Application no: **3/2023/0075**

Address: **Tan Yard Farm Ribchester Road Hothersall PR3 3YA**

Proposal: **Proposed extensions and remodelling (with associated building works) to the existing two barns, to create two detached dwellings (previously subject to approval 3/2021/0771) together with the erection of two proposed detached garages and external works and change of use of land to residential curtilage.**

The Local Highway Authority have viewed the plans and highway related documents and have the following comments to make:

DWG NO: **2264-P01**

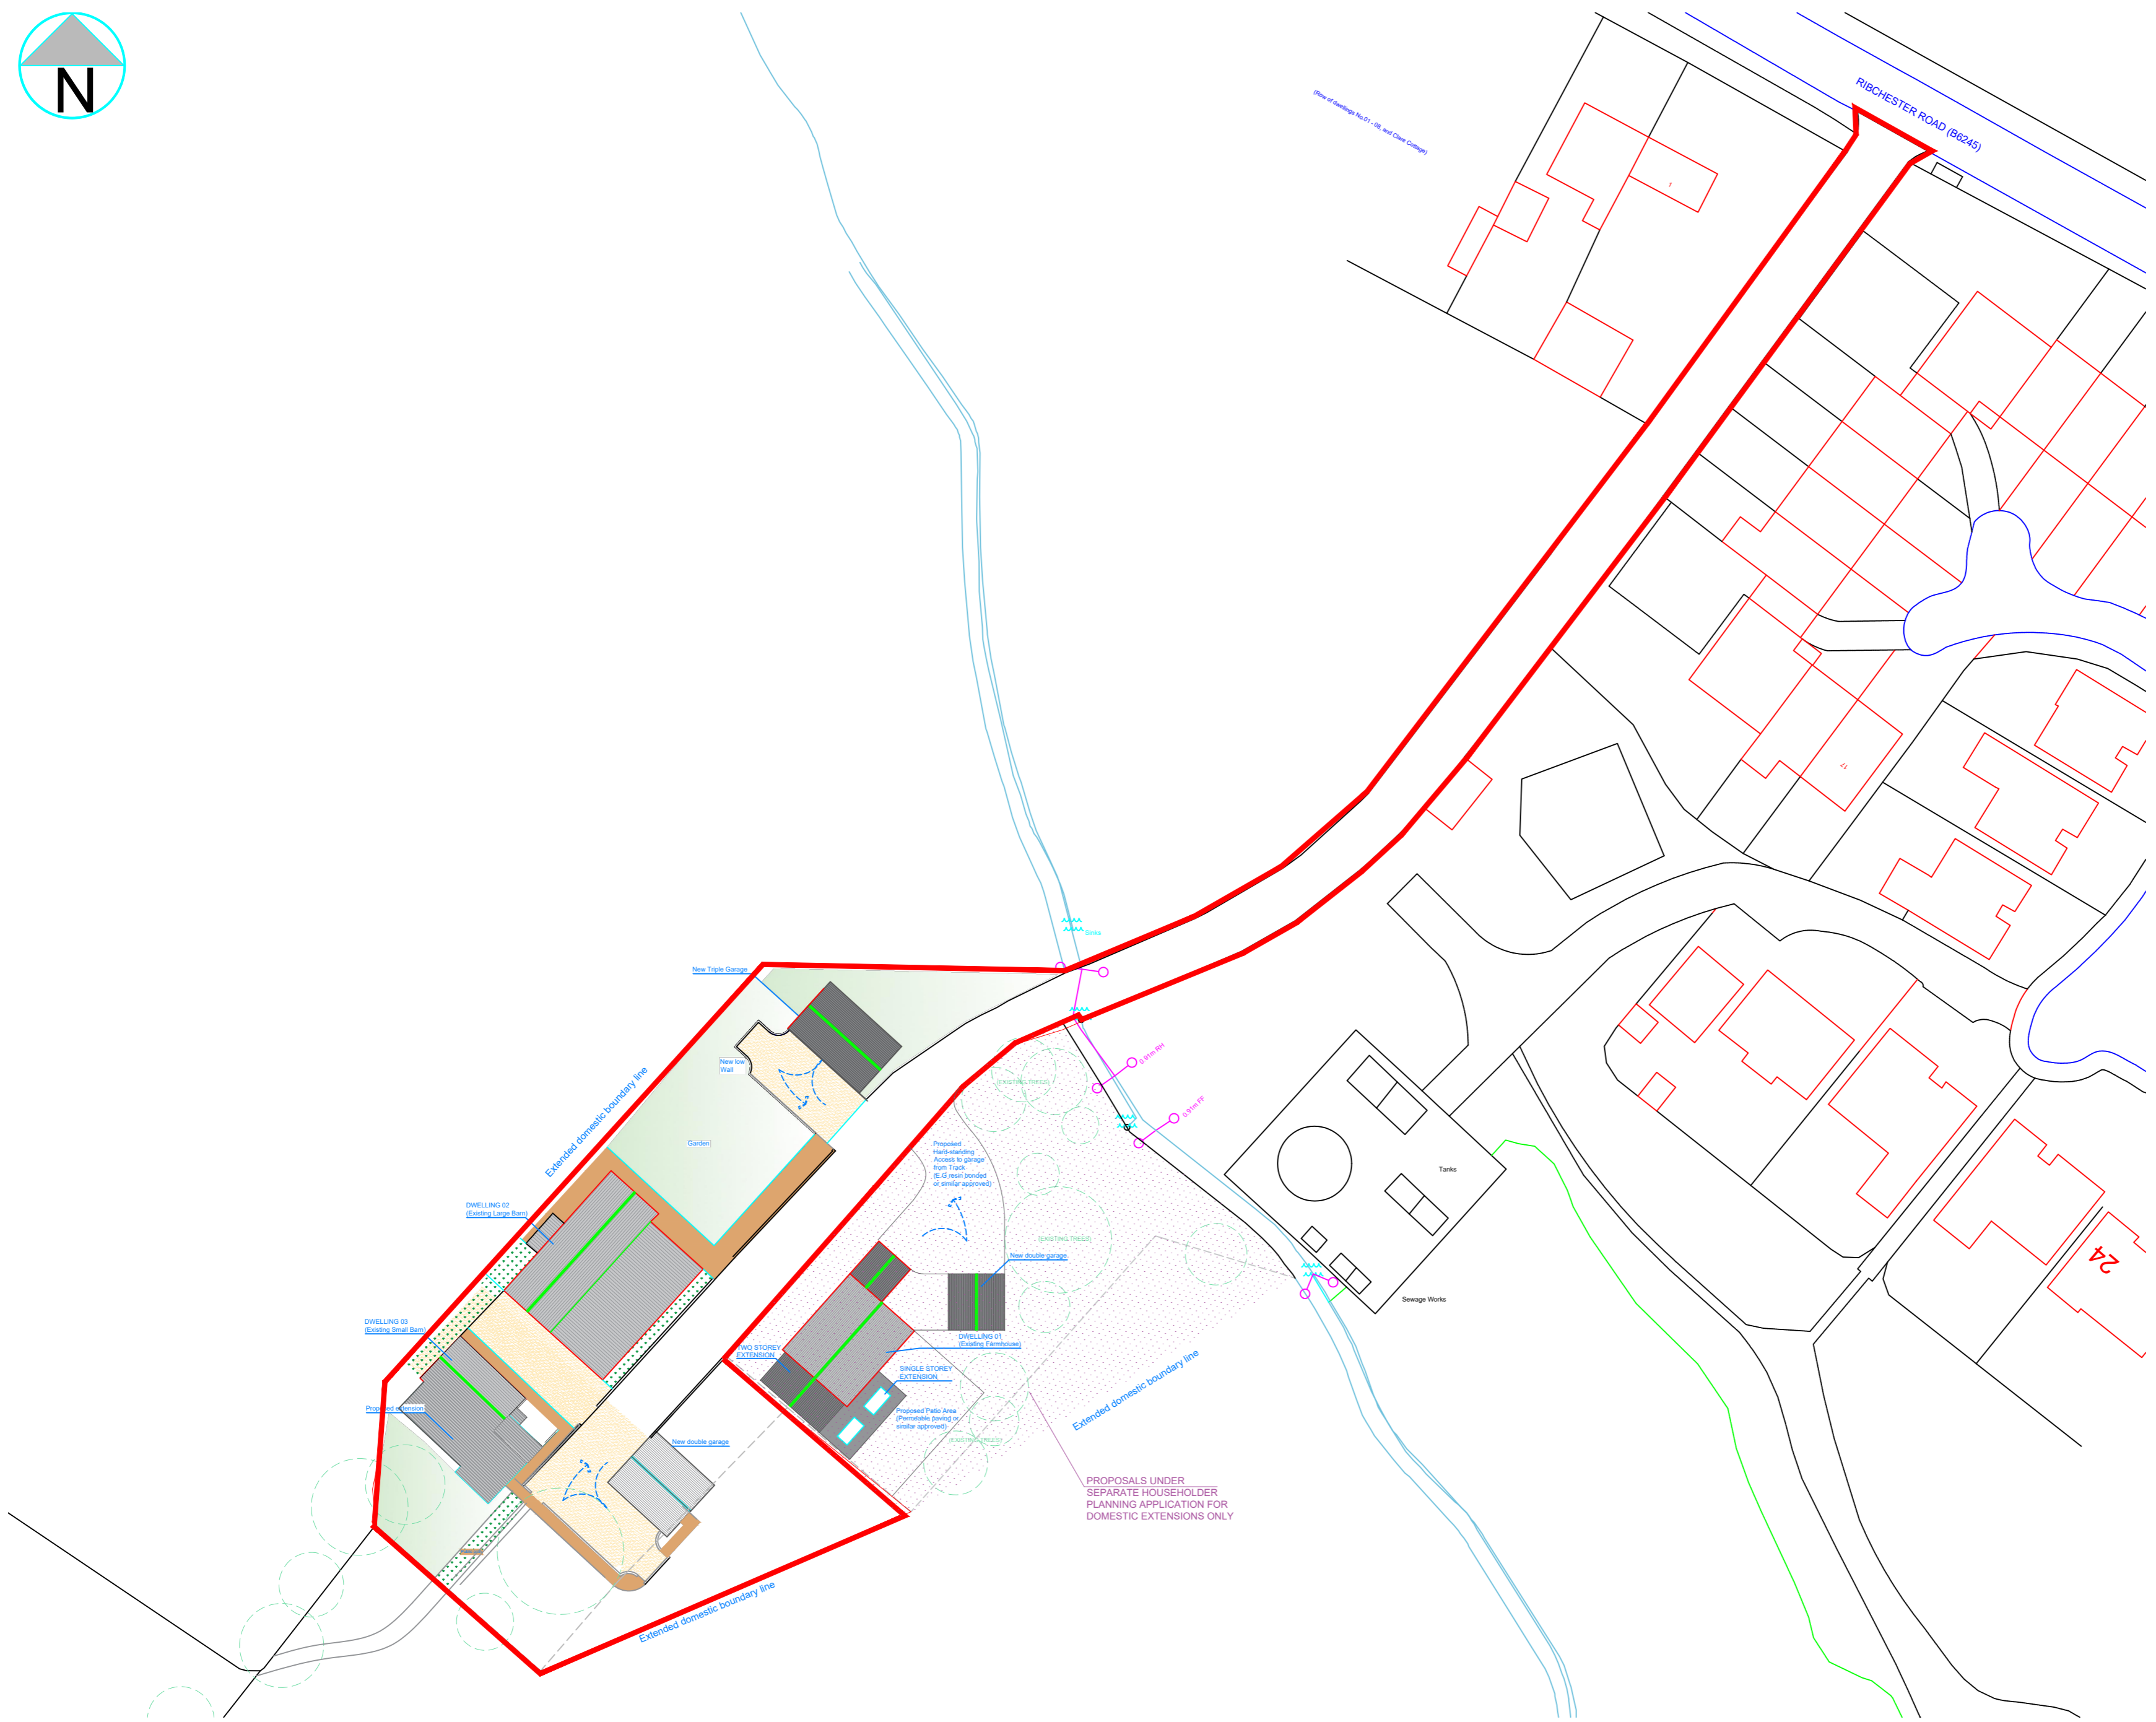
The LHA have reviewed Studio John Bridge drawing number 2264-P01 titled "Proposed Site Plan" and have no comments to make regarding the site access, given that it has already been approved under application reference 3/2021/0771 to serve four dwellings, including the existing farmhouse at the site.

The LHA do advise the Agent/ Applicant that to further formalise the access and make it easier for vehicles accessing and egressing, that the site access should be subject to a Section 278 agreement to radius off the access providing a bell mouth formation.

Should the Agent/ Applicant be willing to do these access improvements, the LHA will request that a revised site plan of the access is provided showing the kerb radii on both sides of the site access.

The LHA have reviewed Studio John Bridge drawing number 2264-P01 titled "Proposed Site Plan" and are aware that Dwelling 2 will provide a driveway and a Triple Garage to serve the parking arrangements at the site for the 4-bed dwelling. This complies with the LHAs parking guidance as defined in the Joint Lancashire Structure Plan. While Dwelling 3 will have access to a detached double garage to serve the 3-bed dwelling.
